Fire Marshal Division

**Re: Maxed Out Garage Paint Booth
39 Gary Denning Dr.
Angier, NC 27501**

Application Number FMFW2009-0006

Maxed Out Garage - 59 Gary Denning Ln., Angier, NC 27501

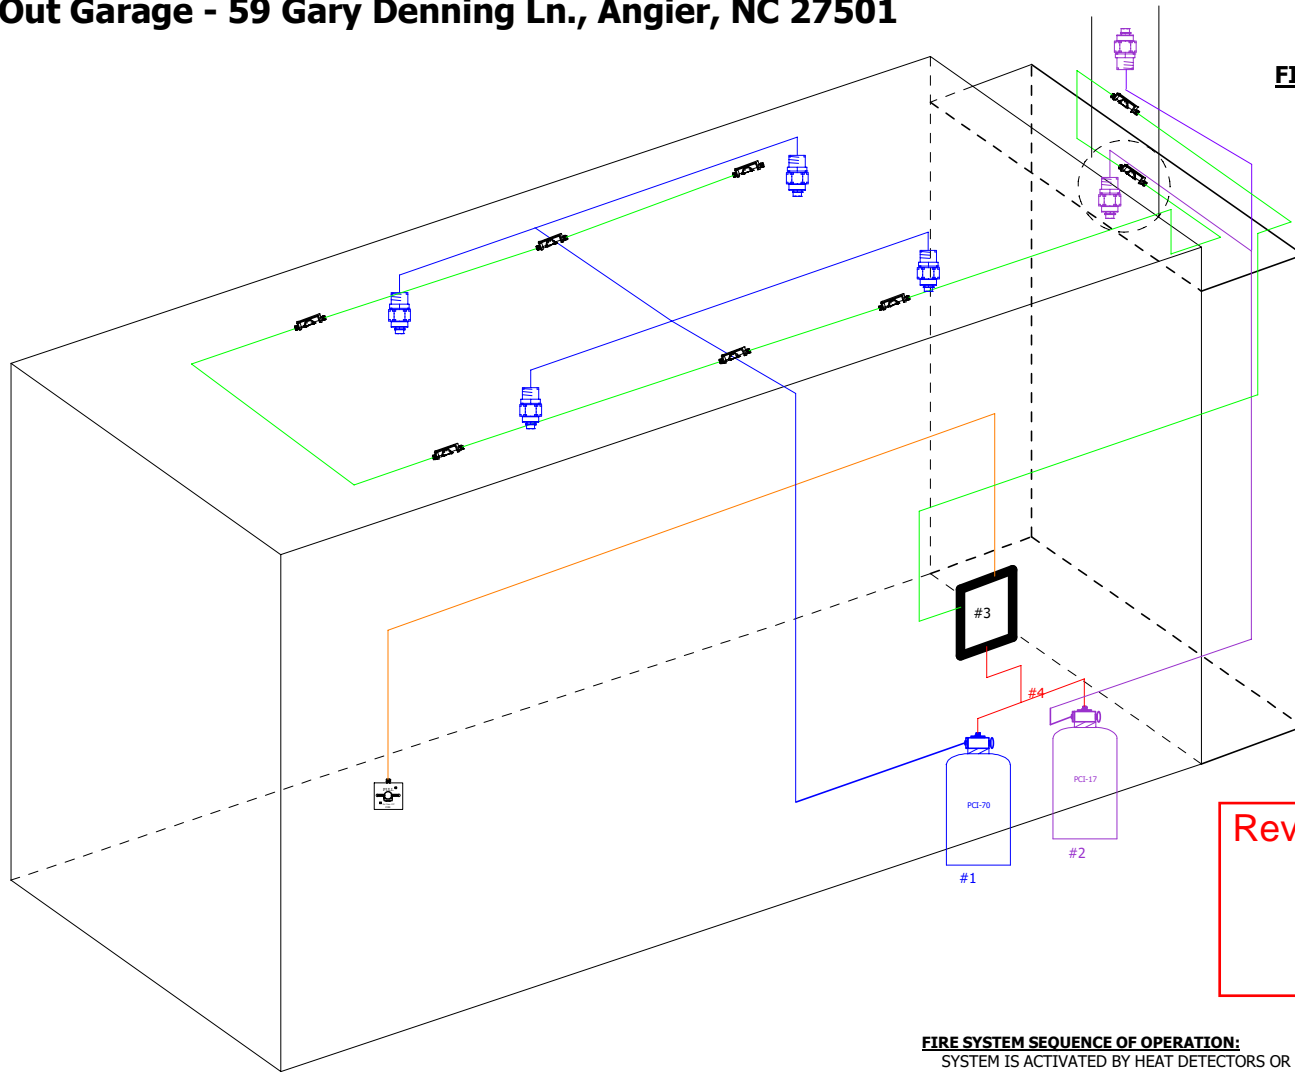
- **Notes**
 - The plans that were submitted indicate “59” Gary Denning Drive. The paint booth is currently in “39” Gary Denning Drive which is also on the plan review application. Please revise and submit before final inspection.
